Our ref: DOC20/408159

Senders ref: SSI 10041

Subject: Notice of Exhibition - Redfern Station Upgrade – New Southern Concourse - SSI 10041

Figure 6 One per cent AEP design flood depths (source: WMAwater, 2015 and WMAwater, 2018)

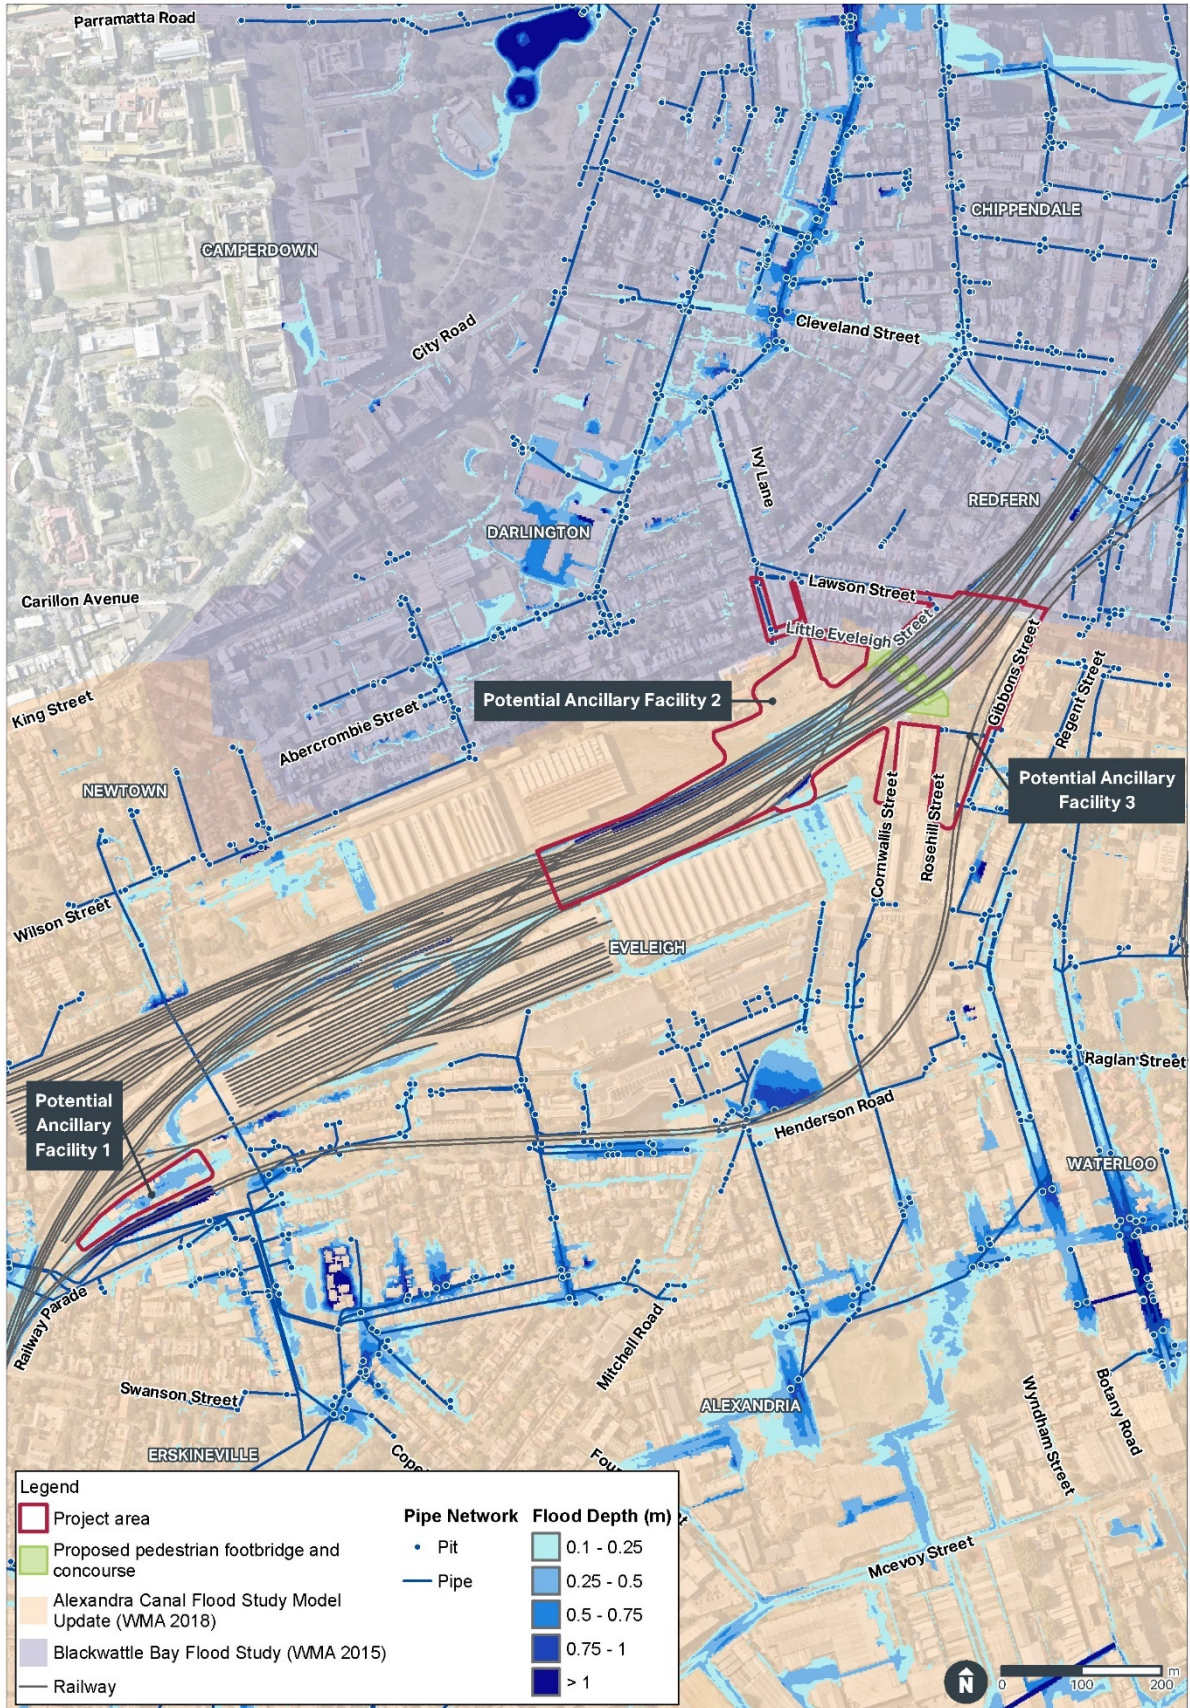
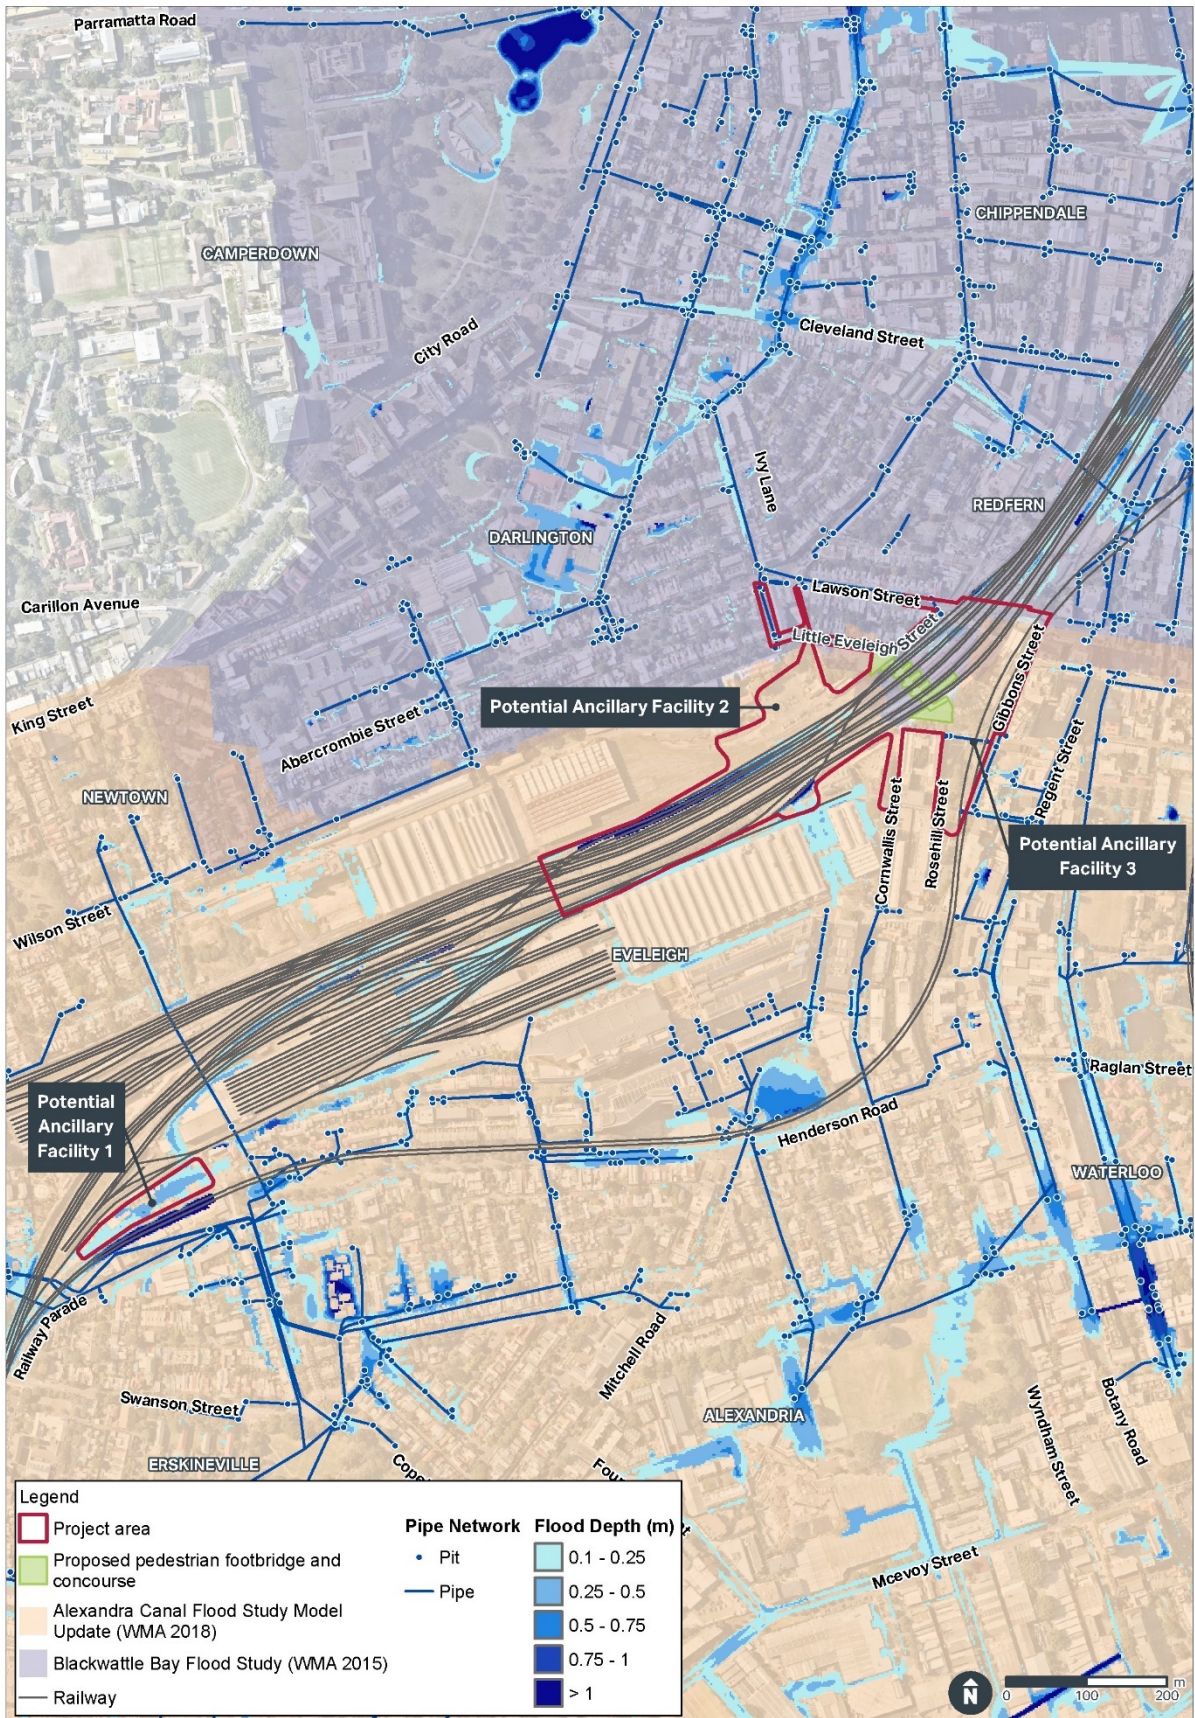
EES has reviewed the Hydrology, Flooding and Water Quality Report prepared by AECOM dated 22 May 2020 and advises that in its current status the report appears not to follow accepted floodplain risk management practice in undertaking a flood impact risk assessment and is considered inadequate as outlined below:

- The assessment does not address existing flood behaviour for the full range of flooding. This should be clearly presented in the report and based on City of Sydney existing flood studies i.e. (Blackwattle-Bay and Alexandra Canal) which show the site impacted by frequent flooding up to the PMF.
- The assessment does not address developed case scenario flood behaviour for the full range of flood events. This is an essential requirement in order to assess the impacts of the development on flooding and on adjacent areas and the impact of flooding on the project and identify management measures to mitigate these impacts including emergency response measures for rarer flood events.
- There are inconsistencies between Section 3.2.1, 1.1.1 and 4.2.1.
